Development Facilitation Team (DFT) – Review Comments

Project No: PR-2023-008608 Date: 08/09/2023 Agenda Item: #4 Zone Atlas Page: E-10

Application For: SD-2023-00144 – Vacation of public easement (DFT)

Project Name: Vacation of Utility Easement at 8035 Kibo Dr. NW

**Plat for  
 Lot 12-A, Block 7  
 Volcano Cliffs Subdivision, Unit 5  
 Being Comprised of  
 Lot 12, Block 7  
 Volcano Cliffs Subdivision, Unit 5  
 City of Albuquerque  
 Bernalillo County, New Mexico  
 January 2024**

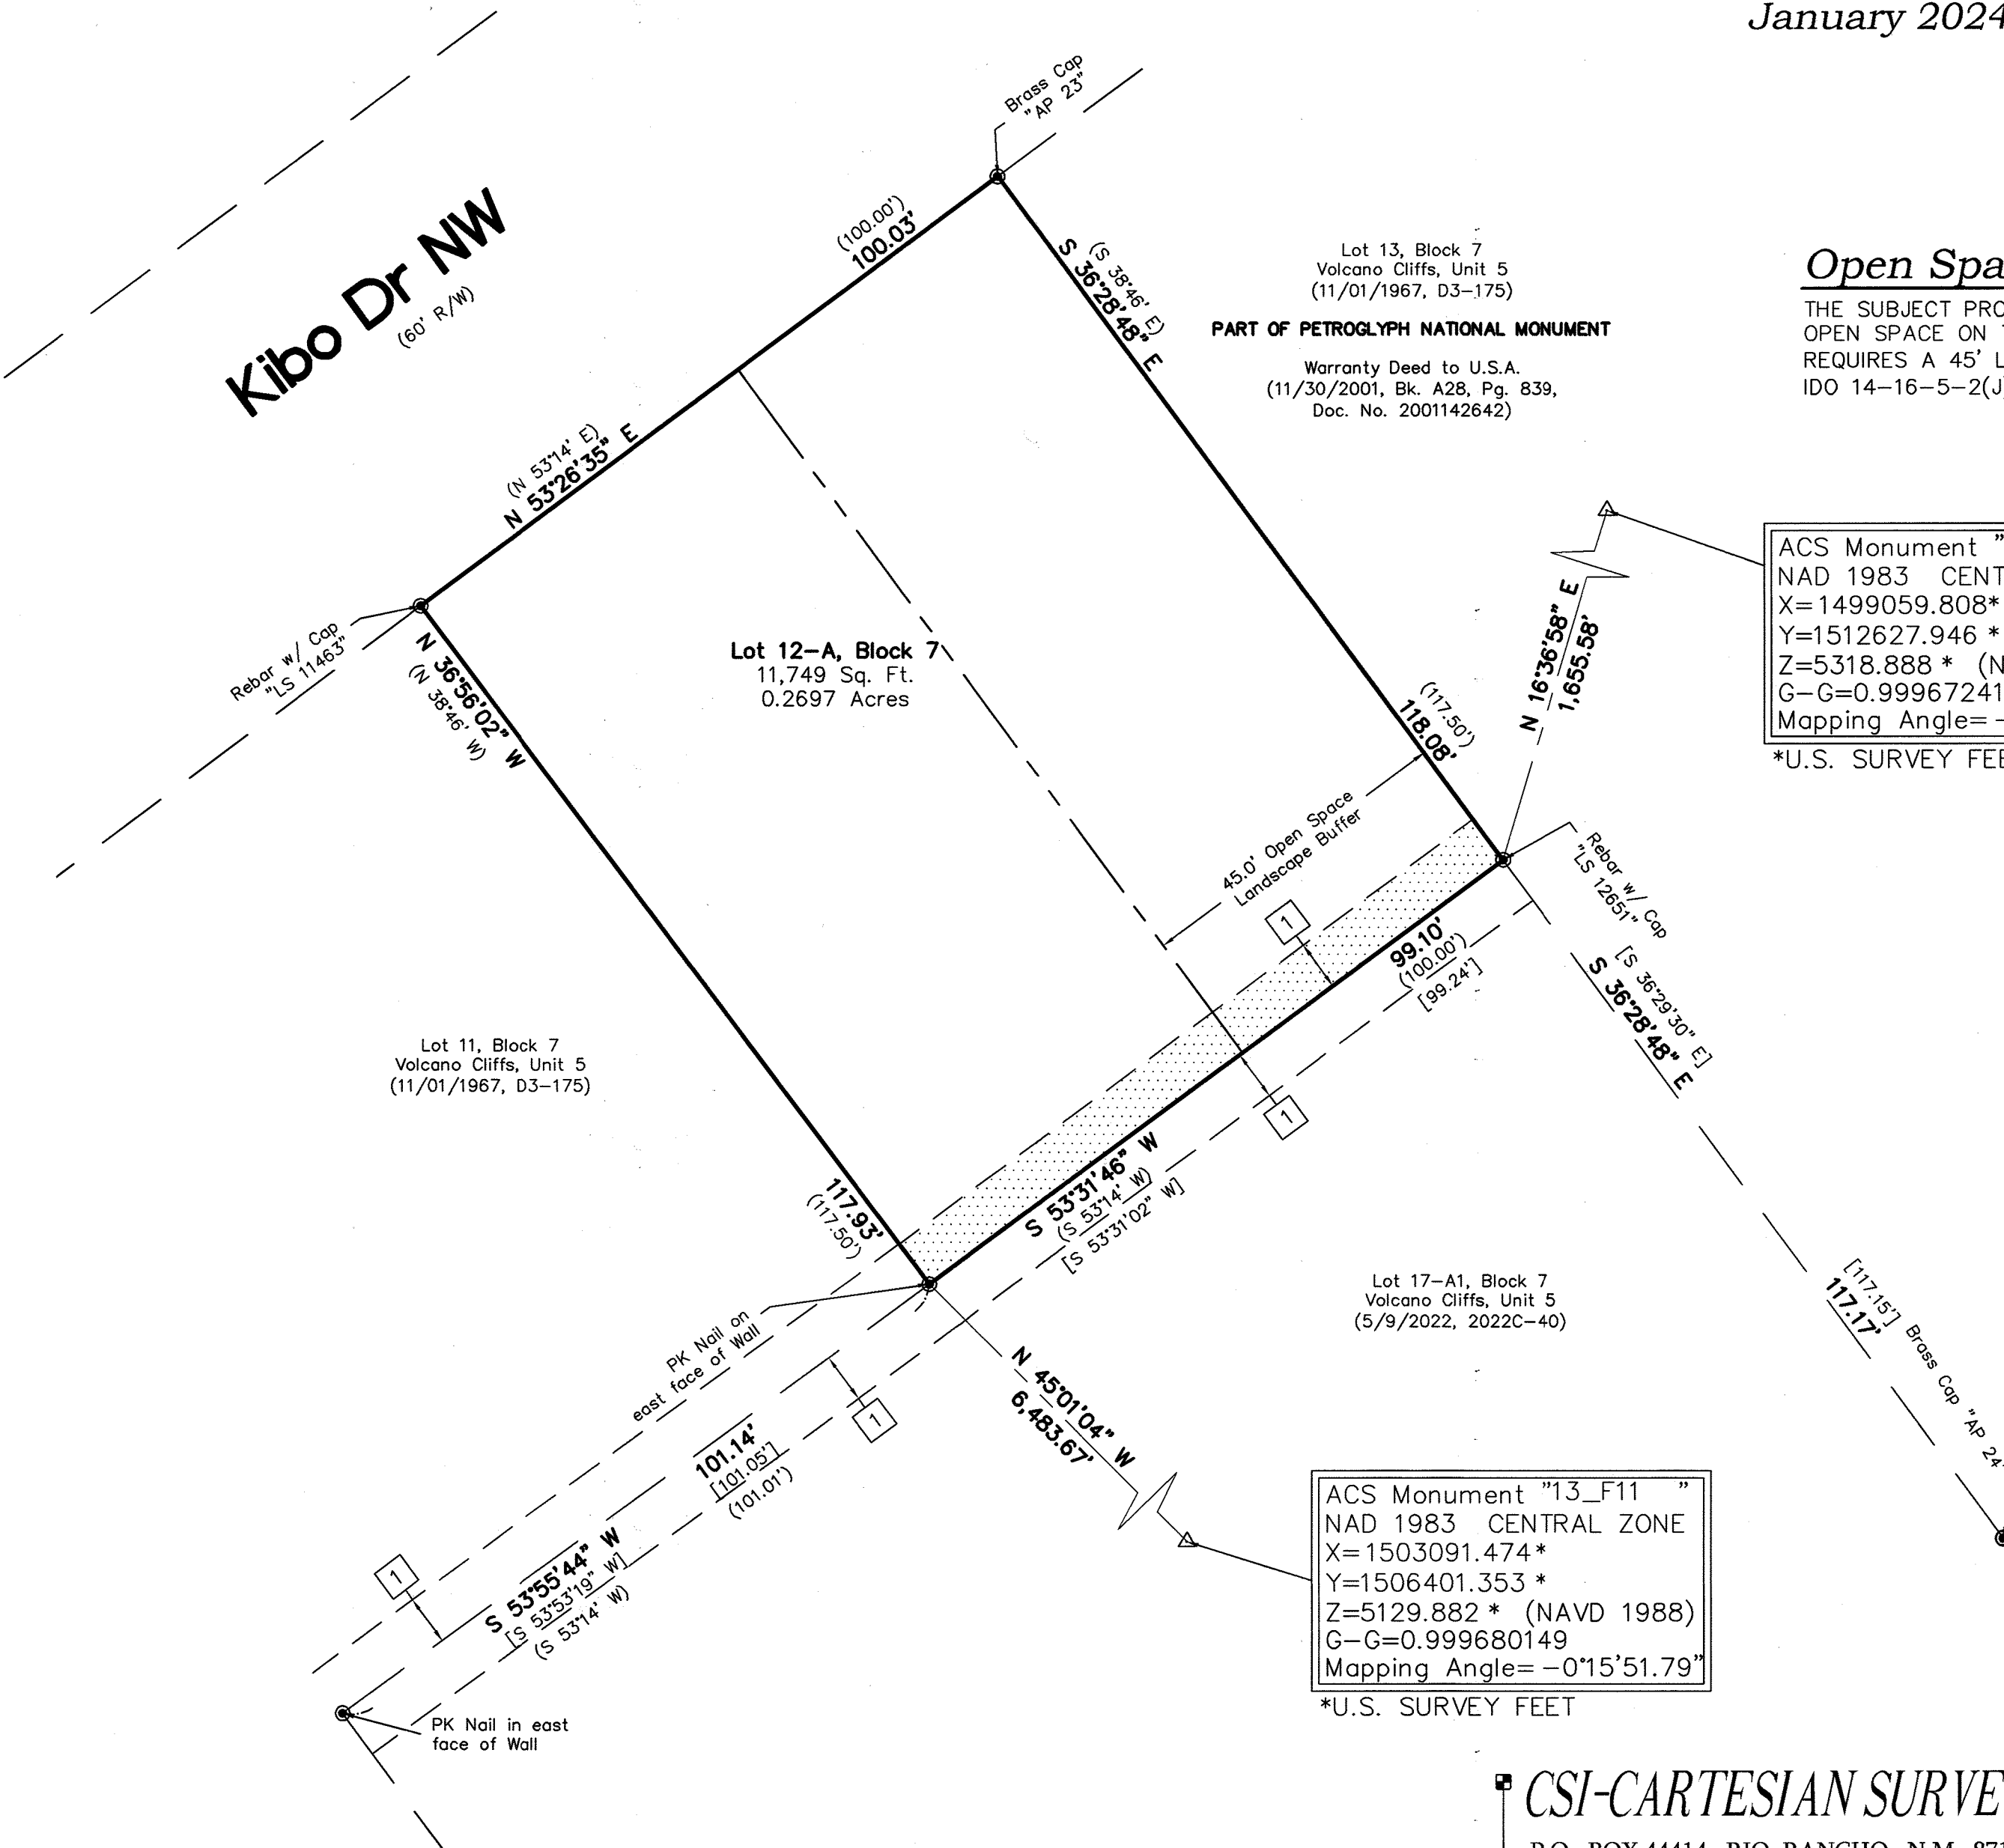
- The Plat needs to include a 45-foot landscape buffer on a new plat where a house is not constructed. The Open Space Superintendent will need to approve any landscaping in this area. No structures are allowed unless they already exist, i.e., the existing house.

Please add “45’ open space landscaping buffer” on the plat with notation that the adjacent property is “Major Public Open Space”. Only plants approved by Open Space may be located within the buffer.

Proposed Utility Easement Vacation

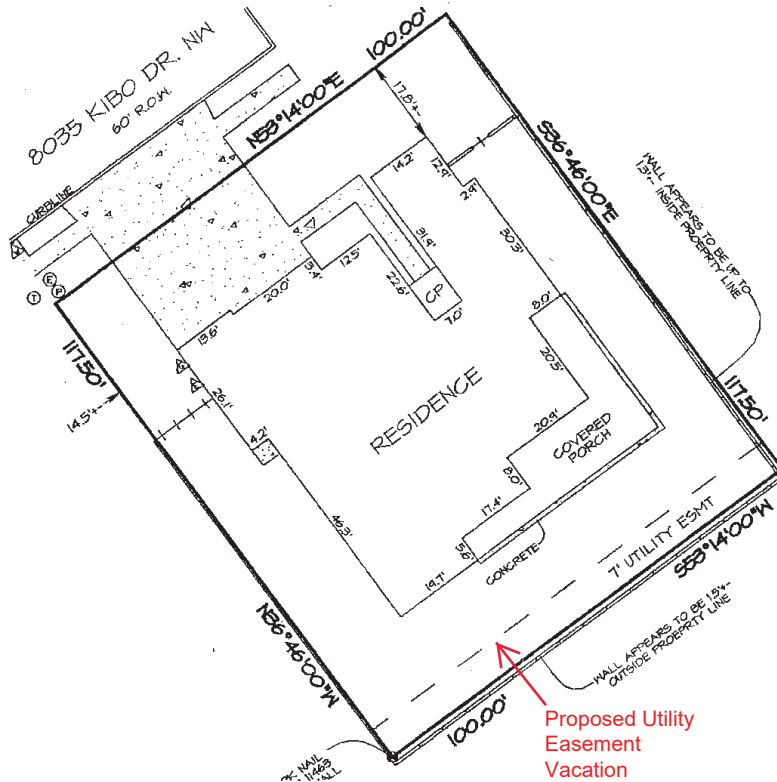
- The Utility easement is not being shown as such on the recorded plat in the application file, however it is shown in an Improvement Location Report (ILR # 213974). Planning staff defers to the City Engineer and the Principal Hydrology Engineer as to whether or not this suffices as proof of the utility easement.
